Response to Submissions Report

813-913 Wallgrove Road, Horsley Park
State Significant Development 5248 - Modification
1

Submitted to Department of Planning, Industry
and Environment
On behalf of Gazcorp

08 June 2021 | 2200495

Figure 4 | SSD-5248 MOD-1 Proposed Concept Plan

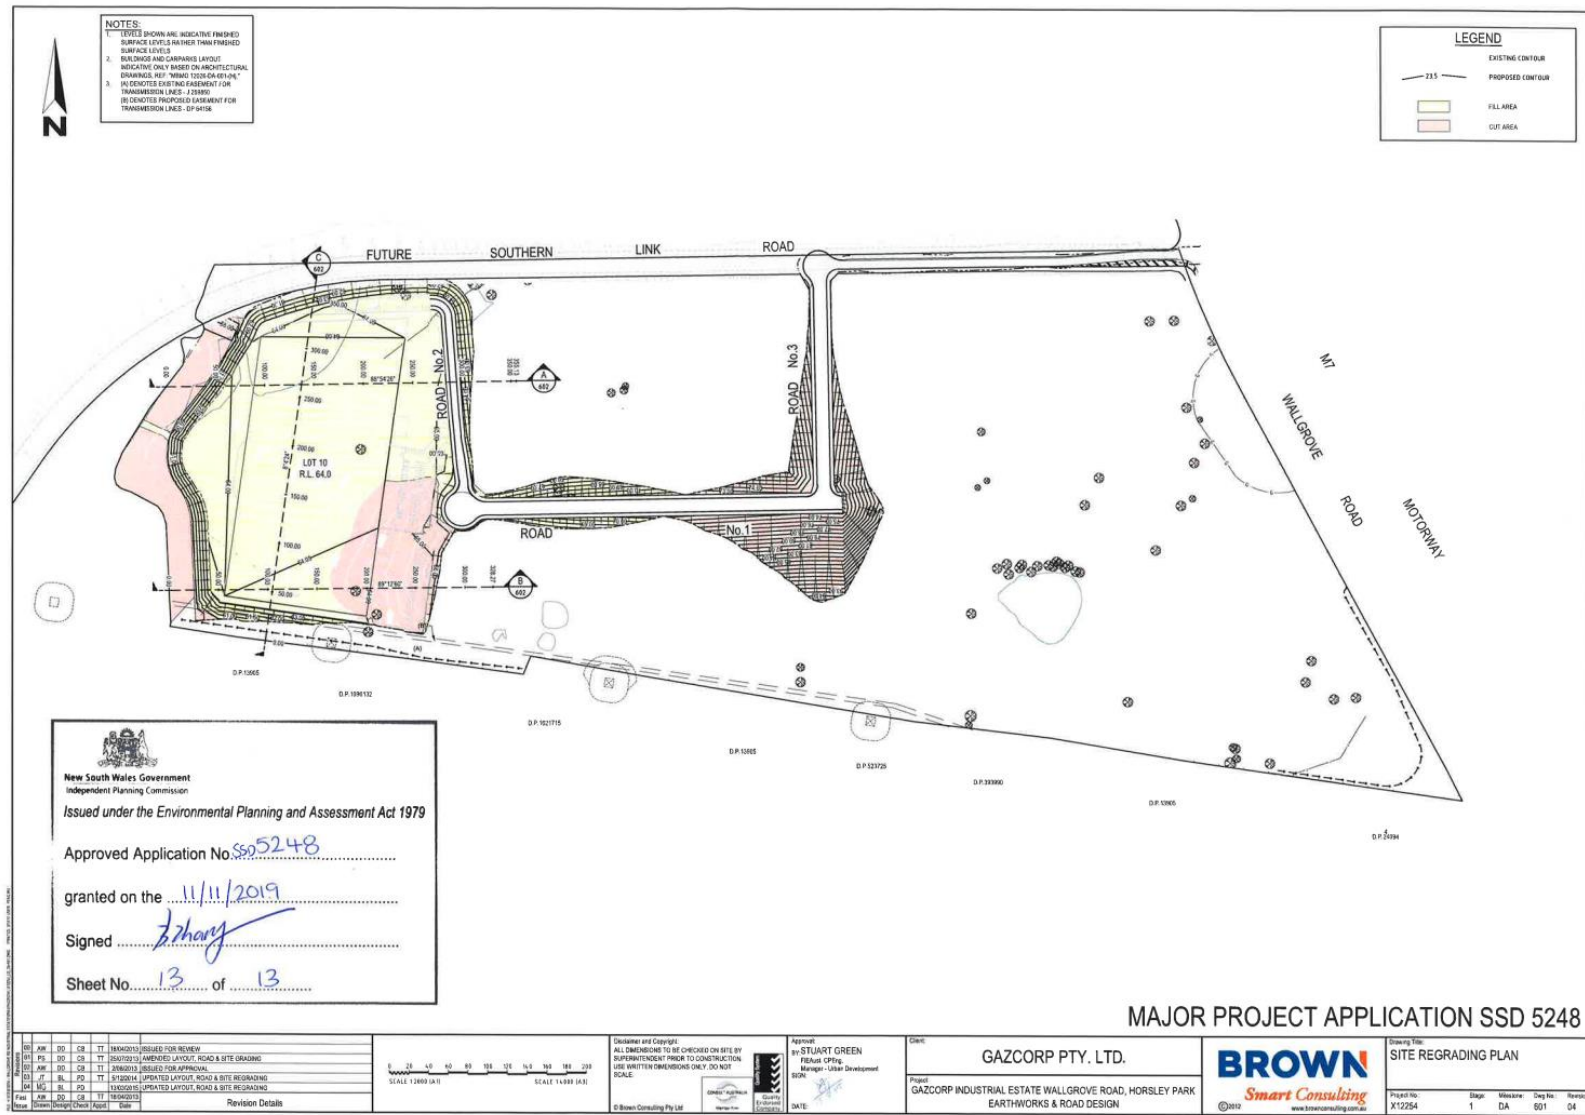
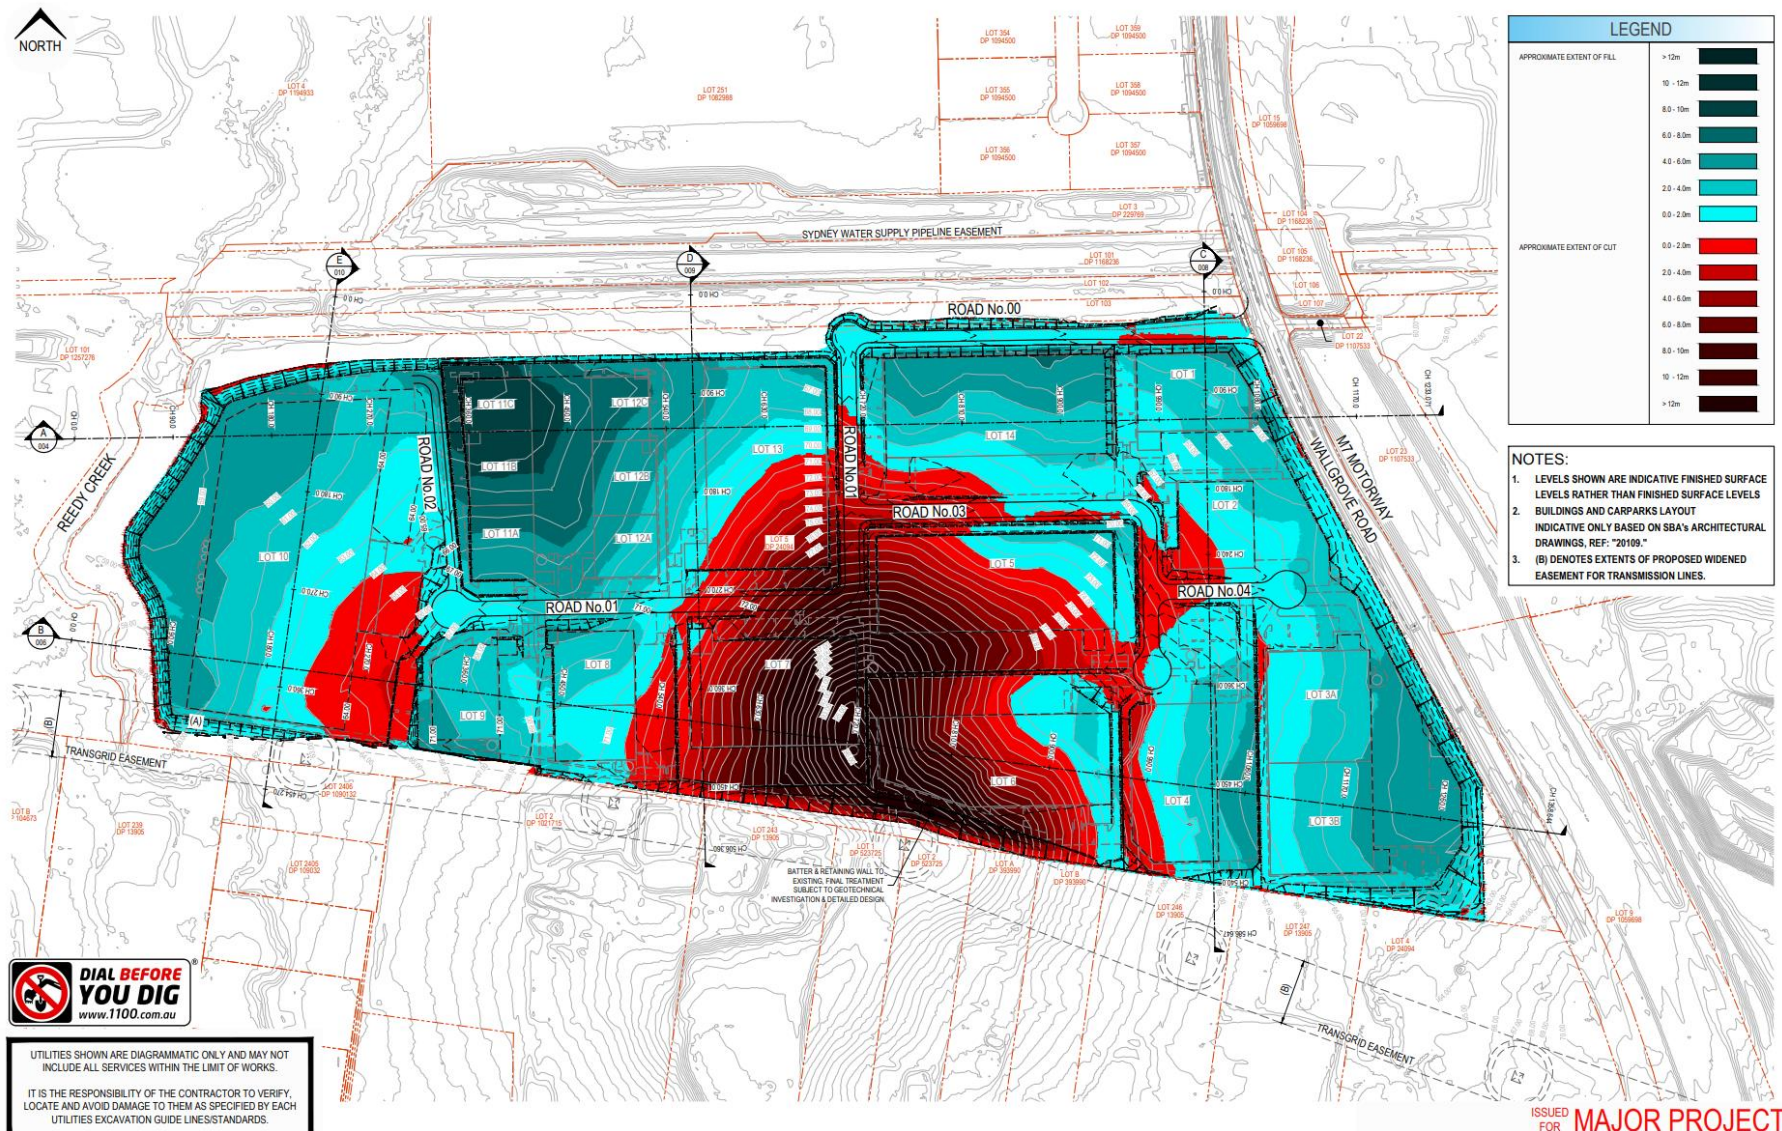
Biodiversity and Conservation Division		
Environment Energy and Science (EES) Group Submission	EES has requested further information in relation to flooding impacts arising as a result of the modification.	A Flood Impact Assessment addendum has been prepared by WBM, and is attached at Appendix B . The Flood Impact Assessment addendum confirms that the amended earthworks plan does not result in any change to the approved flooding impact assessment approved under SSD 5248.
Fairfield City Council		
Traffic generation	All issues raised by TfNSW shall be satisfactorily addressed prior to determination.	Issues raised by TfNSW will be addressed as required by the relevant conditions of consent.
	Further information within a Traffic Management Plan is required demonstrating how traffic entering and exiting the site at one given time will not impact the adjoining road network.	Access to the Site will be by way of a new signalised intersection at Wallgrove Road, which is being constructed by Gazcorp prior to the occupation of the first building. The design of this new signalised intersection has taken into account extensive road traffic modelling, as well as the possible future construction of the Southern Link Road, and has been endorsed by TfNSW.

Swept path diagrams indicate 26m B-Double vehicles manoeuvring within the site will be impacted by trucks parking at the hardstand	As above, the swept paths for individual buildings are conceptual only, and manoeuvring requirements around each building will be subject of future design

area. The design of hardstand areas and manoeuvring areas shall be based on the turning path assessment.	and planning approval processes, taking into account specific user requirements for each building.
	Turning path diagrams show that 12.5m long heavy rigid vehicles entering the car park need to use the entire driveway to enter/ exit the carpark, this will conflict with other users of the car park.	As above.
Stormwater Management	The stormwater plans prepared by Orion Consulting Project No. 19-0108, Sheet DA 200(B) is not acceptable in its current form. Further information is requested.	In accordance with Condition C47 of the approval for SSD-5248, detailed stormwater plans will be prepared prior to the commencement of construction. As required under this condition, the stormwater management system must demonstrate consistency with Council's Stormwater Management Policy (September 2017), and must be prepared in consultation with Council.

A Loading Management Plan shall be provided identifying the type and frequency of vehicles servicing various lots on an hourly and/or daily basis.	Condition B4 of the existing consent requires details of loading and unloading to be taken into account in future development applications for individual buildings, to be documented in a traffic and transport report. Condition C40 requires the preparation of an Operational Traffic Management Plan for the first Stage 1 building, prior to the commencement of operation, which would take into account user requirements for loading and unloading.
Driveways and carpark	The turning swept path diagrams for 26m B-Double vehicles illustrate that vehicles require full width driveways and travel onto opposite lane on the Estate Road, potentially impacting oncoming traffic and parked vehicles.	The Estate Road is a private road that solely services the industrial estate. It is therefore not unreasonable that trucks may occasionally need to manage conflicts on this road, noting that it will not impact on the operation or efficiency of any public road. The adequacy of each driveway, and how it might affect the operational functioning and efficiency of the estate road will be considered in the design and planning approval for each subsequent building – noting that, whilst the Stage 1 civil works will include the construction of the estate road, it will not include the driveway crossovers for each building, which will be subject of future design processes, taking into account user requirements for each building.
